29 FLORIDA STREET  
SYLVANIA (SSD-83258708)

RESPONSE TO SUBMISSIONS

REVISION 04

26.03.26

GA - OVERALL - LEVEL 05

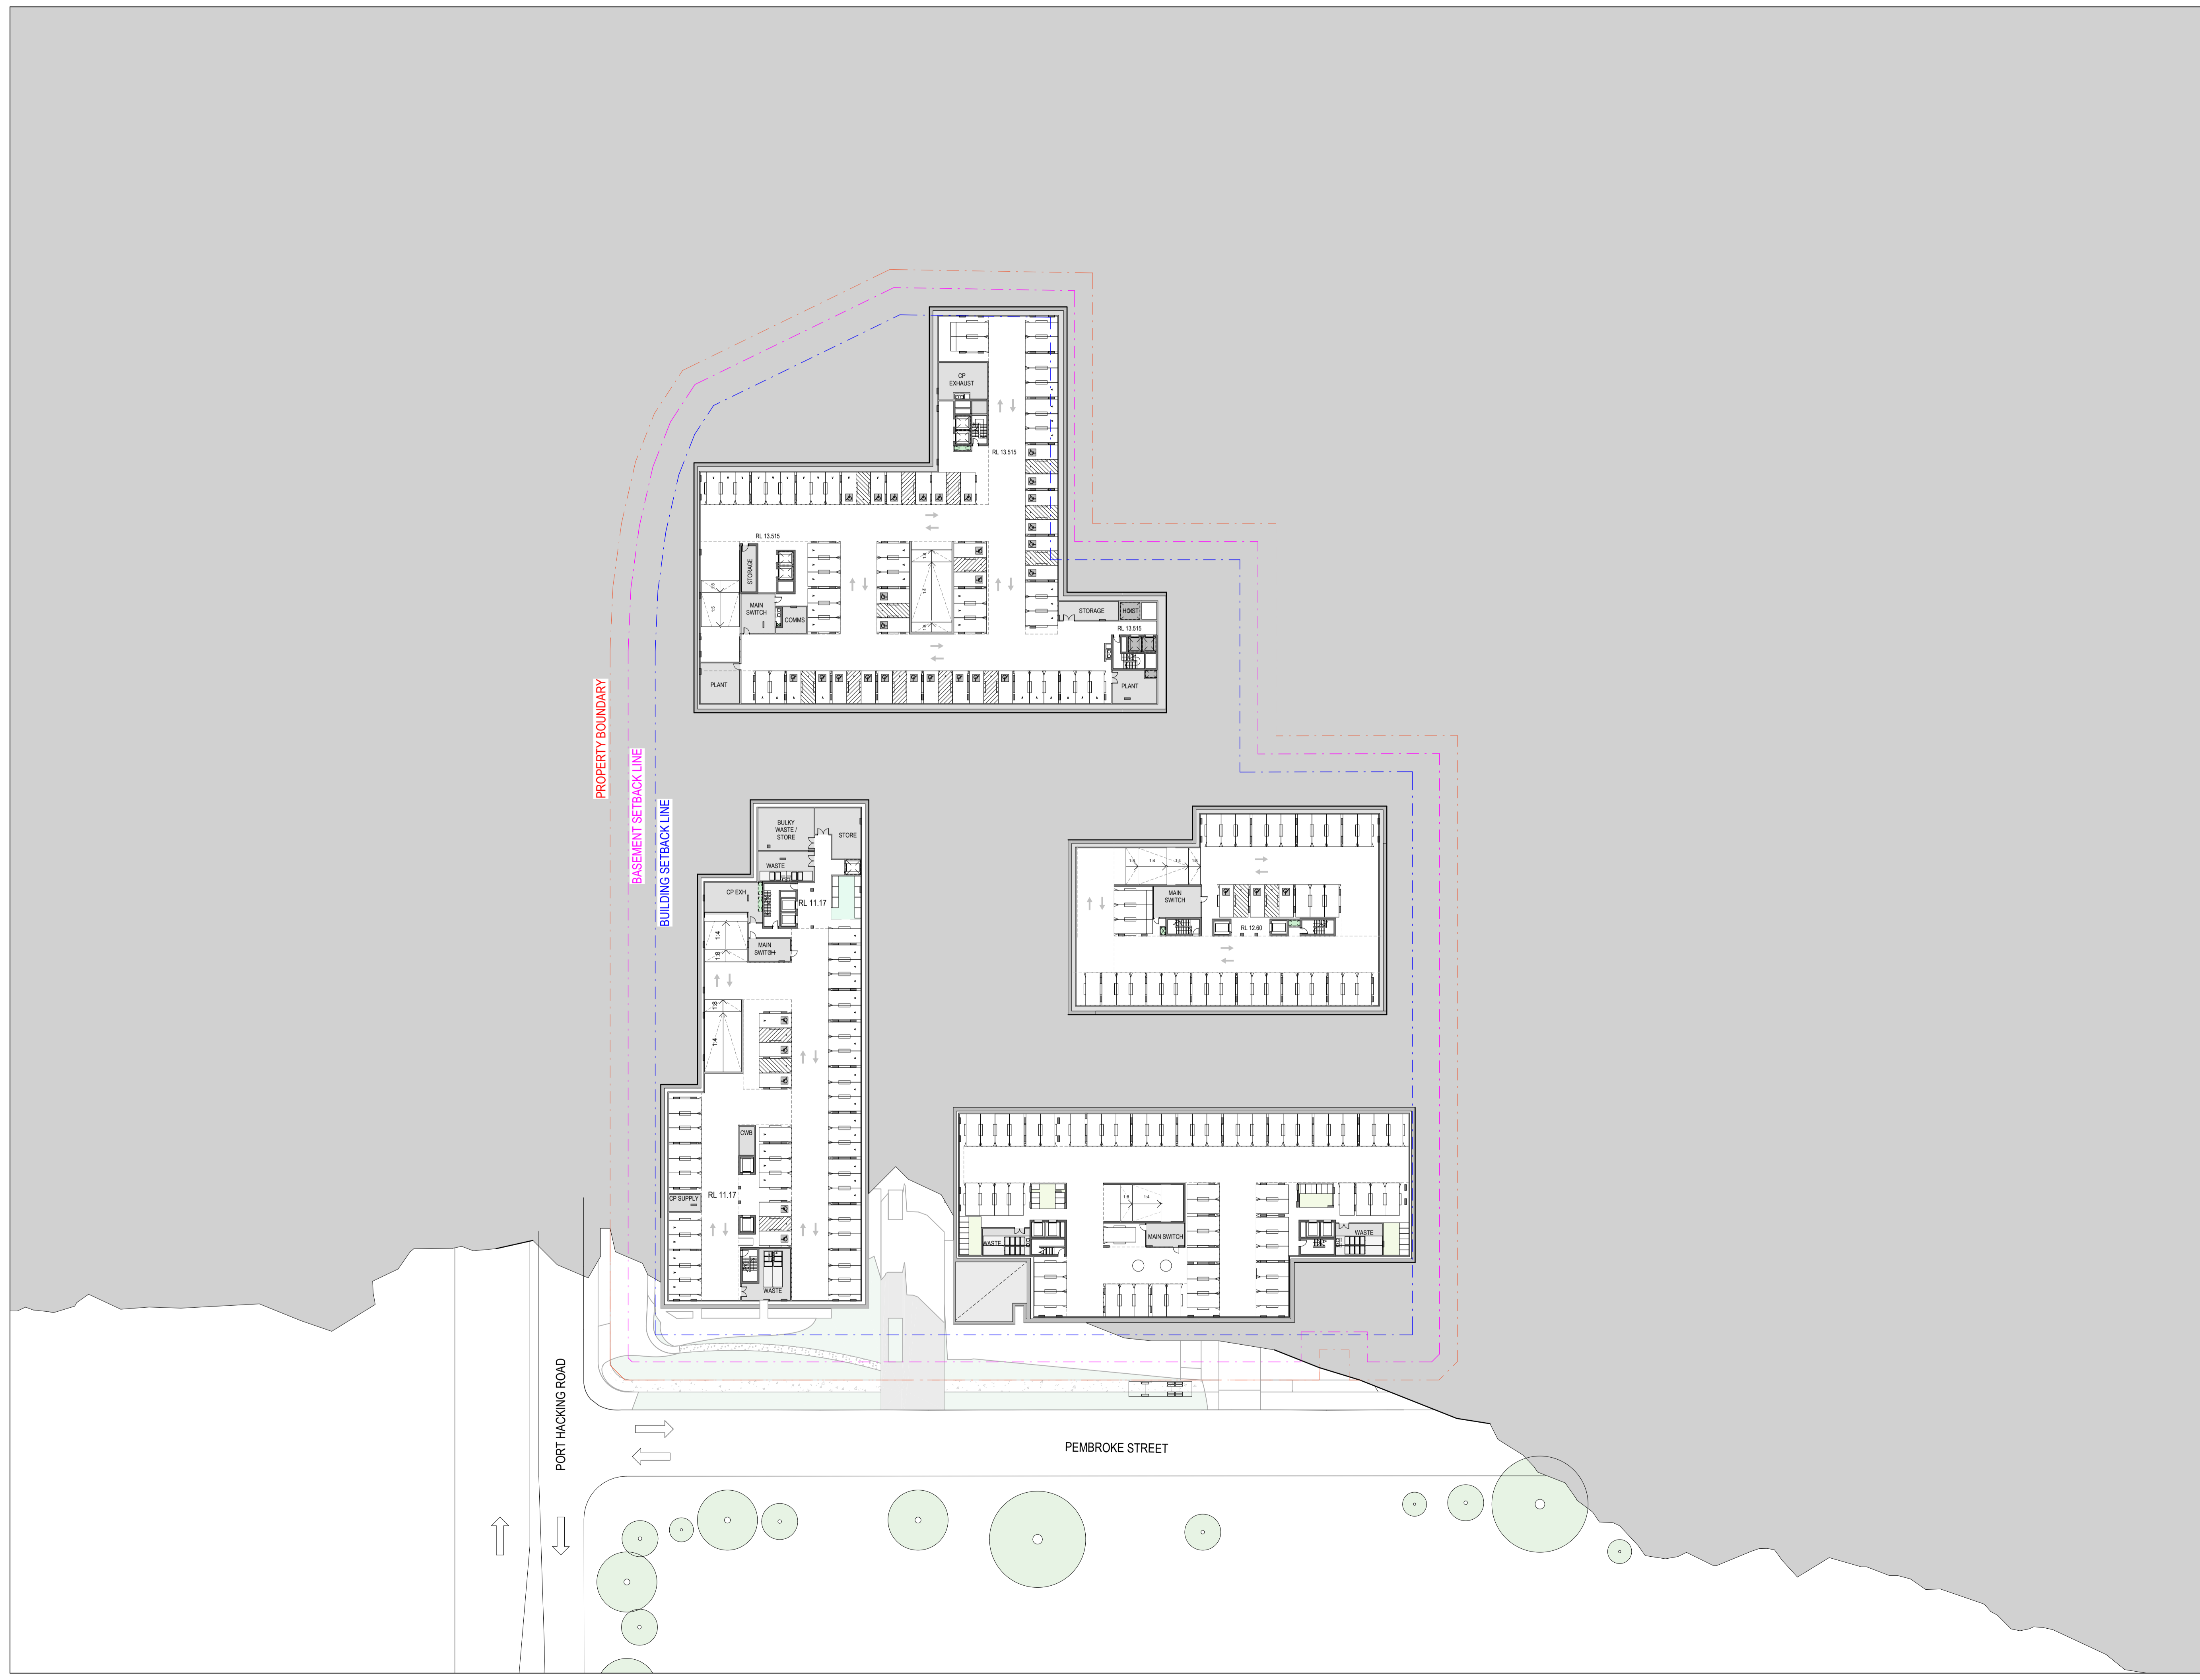
NO.	ISSUE RAISED	RESPONSE
<b>BUILT FORM &amp; URBAN DESIGN</b>		
7.1	As the proposal seeks to rely on Council's waste collection services, the waste servicing arrangements outlined in Council's submission dated 22 January 2026, along with Council's concerns with the design and function of the proposed internal road, must be addressed.	BVN have reviewed the proposed ground floor planning of Market Building 2 and coordinated with JMT Traffic and MRA Waste consultants to reduce the non compliant distances from waste room holding areas to waste vehicle parking on the internal road as reflected in the diagrams below. This will result in a minor re-plan of the lobby areas to the market building, and switching locations of the waste rooms with the 2bed on the other side of the lobby. As a result, waste vehicles servicing this building can park closer to Florida Street and, as indicated in the swept path, this will in turn shift the parking area for waste vehicles into Market building 3 closer to this waste holding area. Basement areas will also need a minor re-plan to coordinate hoist locations bringing waste bins up from the basement. Further clarification and detail has been provided as part of responses to submissions from waste and traffic consultants.

- WASTE VEHICLE SWEEP PATH FROM MARKET BUILDING 2 ALLOWS THIS PARKING AREA TO MOVE CLOSER TO THE WASTE HOLDING AREA AND REDUCE THE DISTANCE TO BELOW 10M
- WASTE VEHICLE PARKING TO SERVE MARKET BUILDING 2 IS WITHIN 10M OF WASTE HOLDING AREAS AND IS AT GRADE
- 2BED LOCATION SWITCHED TO OTHER SIDE OF LOBBY TO LOCATE WASTE FACILITIES CLOSER TO FLORIDA STREET FOR MARKET BUILDING 2
- ADDITIONAL CHANGES TO GROUND FLOOR FIRE PUMP ROOM AND TANK AREAS HAVE BEEN INCLUDED AS PART OF RESPONSES TO OTHER ITEMS

1 Section 04

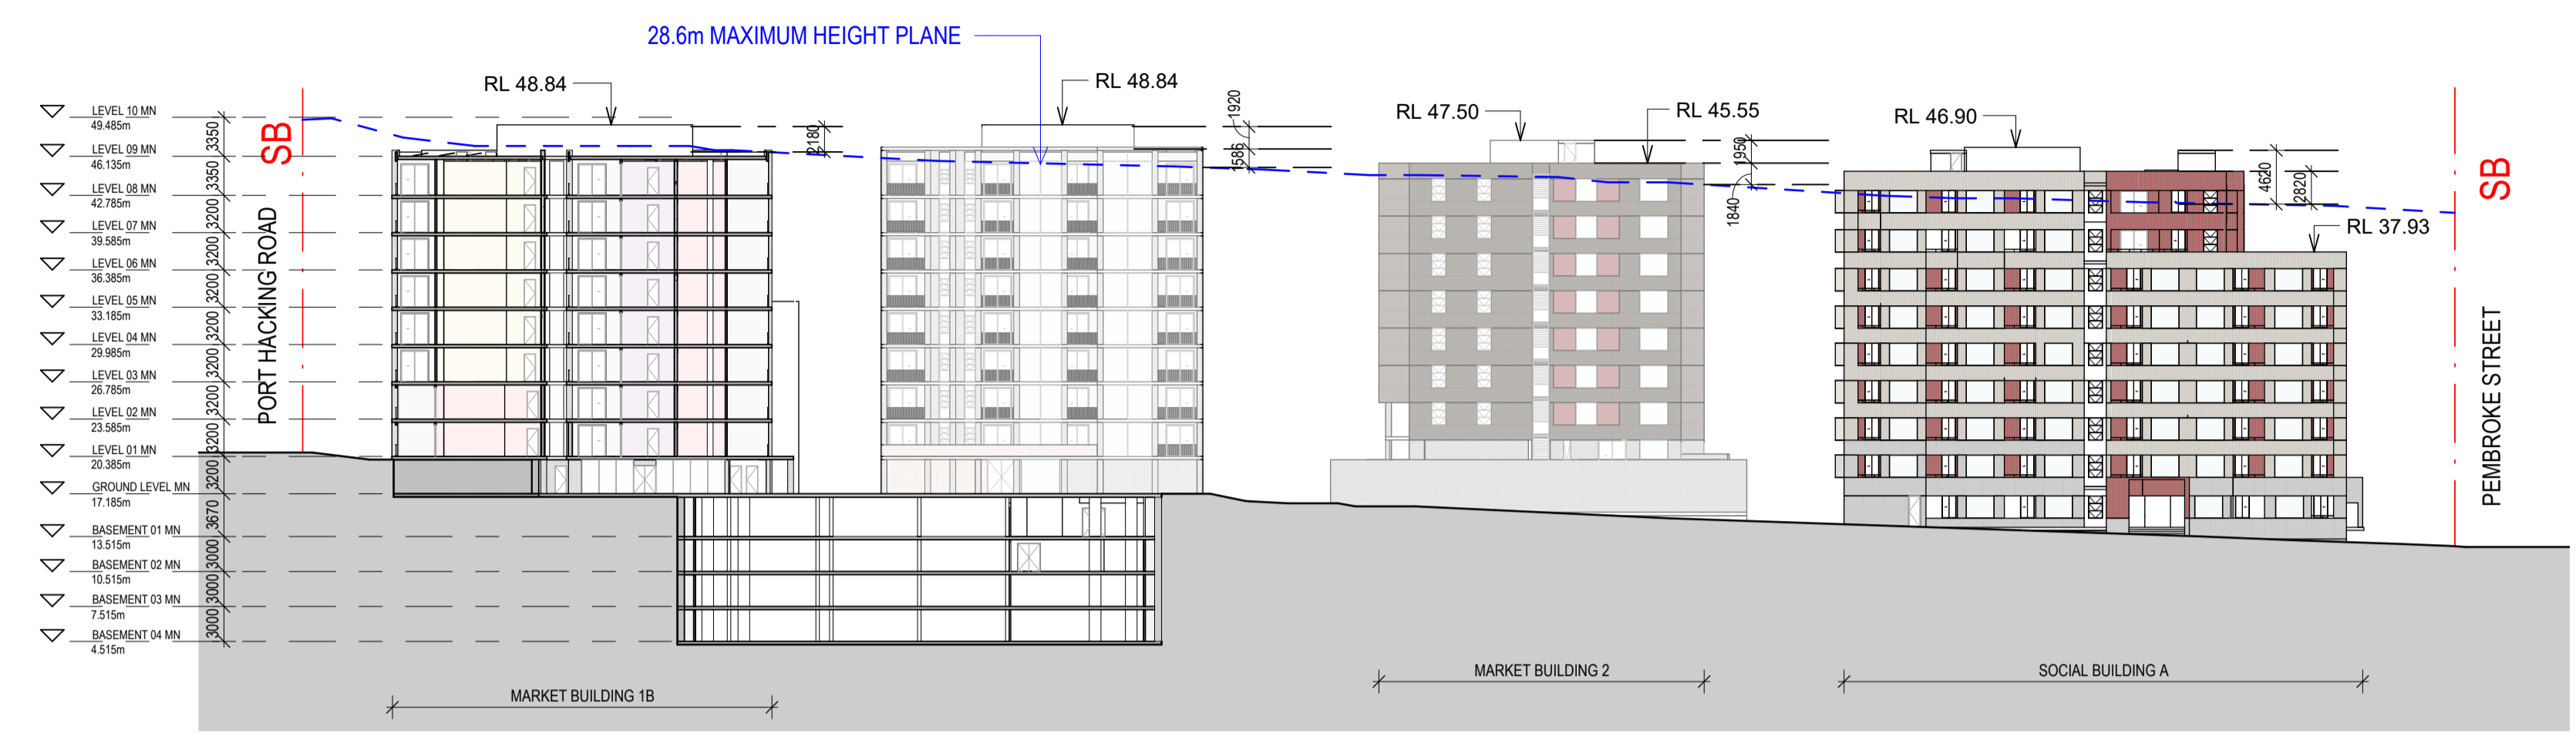
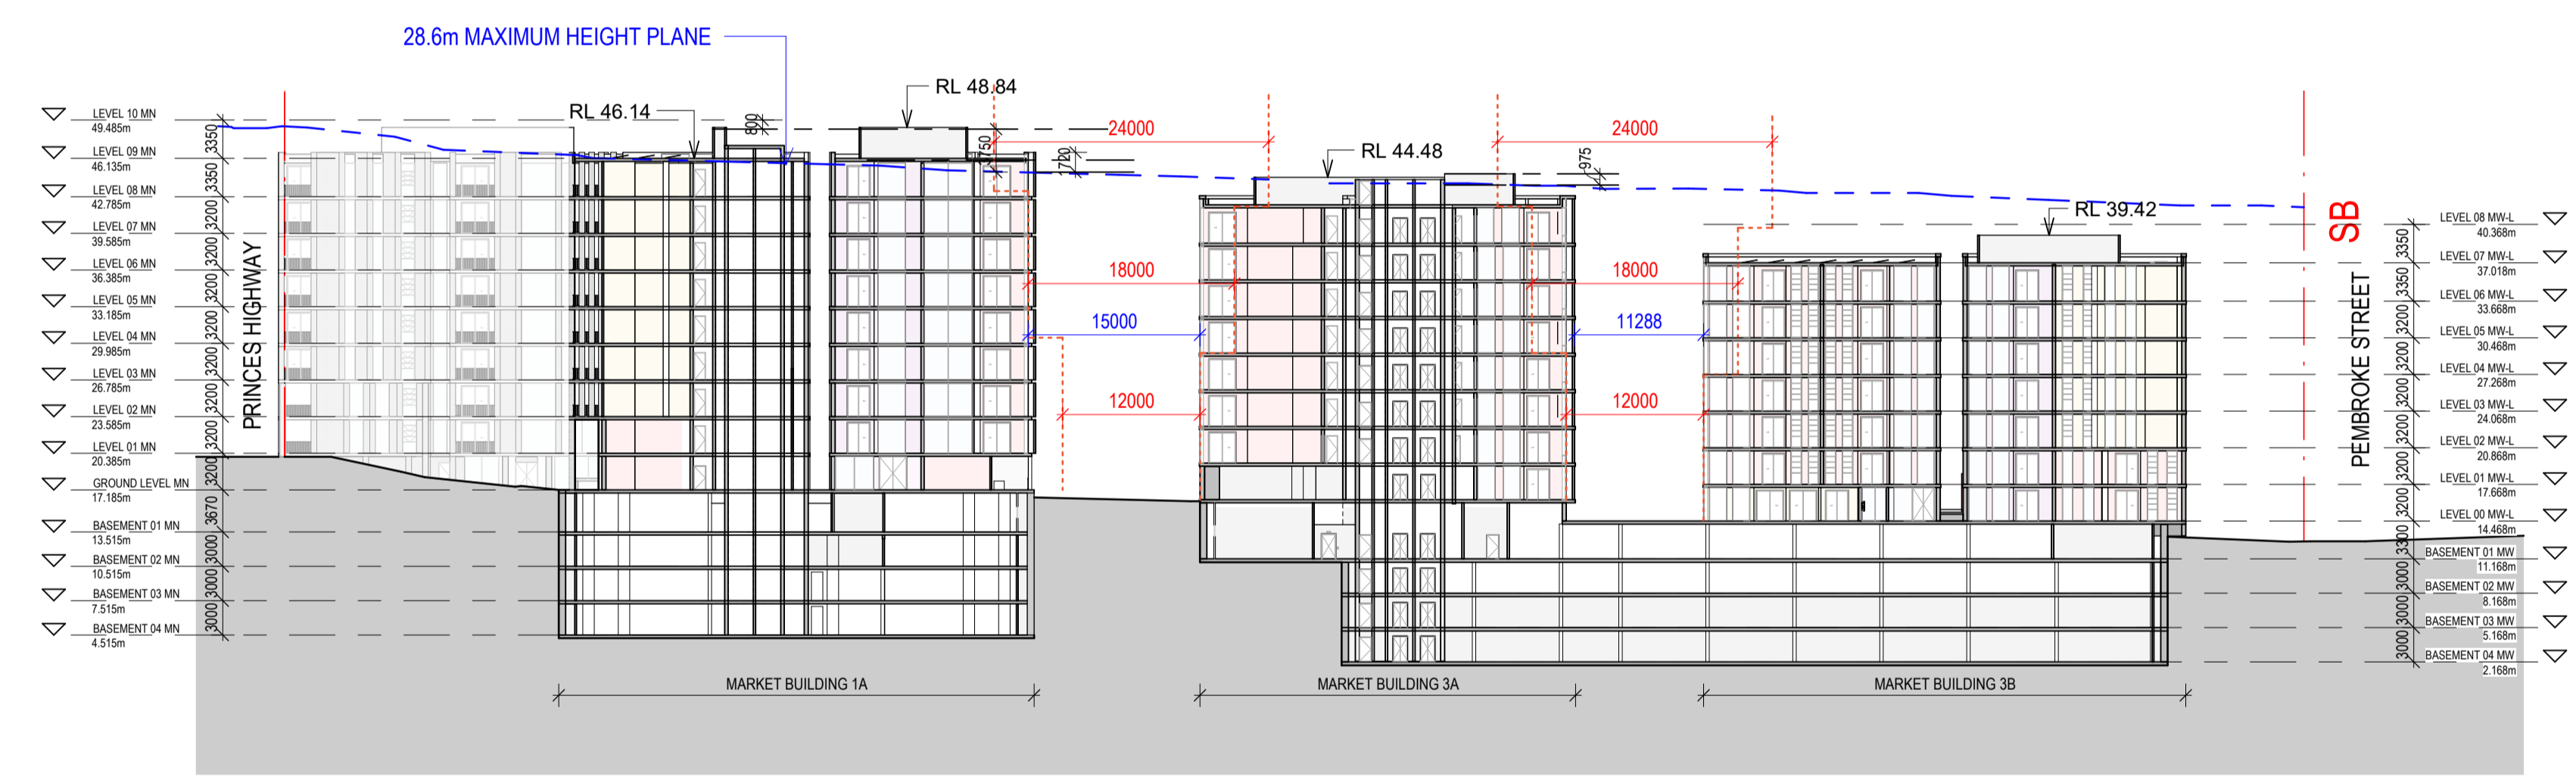
NO.	ISSUE RAISED	RESPONSE
<b>BUILT FORM &amp; URBAN DESIGN</b>		
4.1	Provide a schedule detailing where recommended Apartment Design Guide (ADG) building separation distances (i.e. Part 3F) are not achieved and the proposed mitigation measure (e.g., façade privacy screening as outlined in the Architectural Design Report) that are to be implemented to ensure satisfactory visual privacy is achieved.	A summary of non compliances with ADG building separations has been provided as part of the Archtiectural Design Report. Greater detail, locations and privacy amelioration techniques has been provided below.

LOCATION	DESCRIPTION	PRIVACY CONSIDERATION
1.0	Building separation between Market Building 1 A and 3A along Port Hacking Road. Building separation between Levels 5 - Level 8 is 15m in lieu of 18m	Angled privacy screening to Market Building 1A applied to secondary bedrooms along the southern facade. Internal planning and arrangement of apartments orientates balconies and primary habitable spaces to the east and west. Balconies are screened with vertical pier elements

2.0	Building separation between Market Building 3A and 3B along Port Hacking Road. Building separation between Levels 1-4 is less than 12m Building separation L5-L8 is less than 18m	Angled privacy screening to Market Building 3A applied to secondary bedrooms along the southern facade. Internal planning and arrangement of apartments orientates balconies and primary habitable spaces to the east and west

3.0	Building separation between Market Building 2 and eastern wing of Social Housing on Levels 5-8 is 12m in lieu of minimum 18m	Angled privacy screening to the northern facade of the social housing building provides privacy to secondary bedrooms on this facade. Planning and fenestrations in this facade have been curated to ensure they are offset from any opposite facing windows of Market Building 2, and, all primary facades of both buildings face east and west
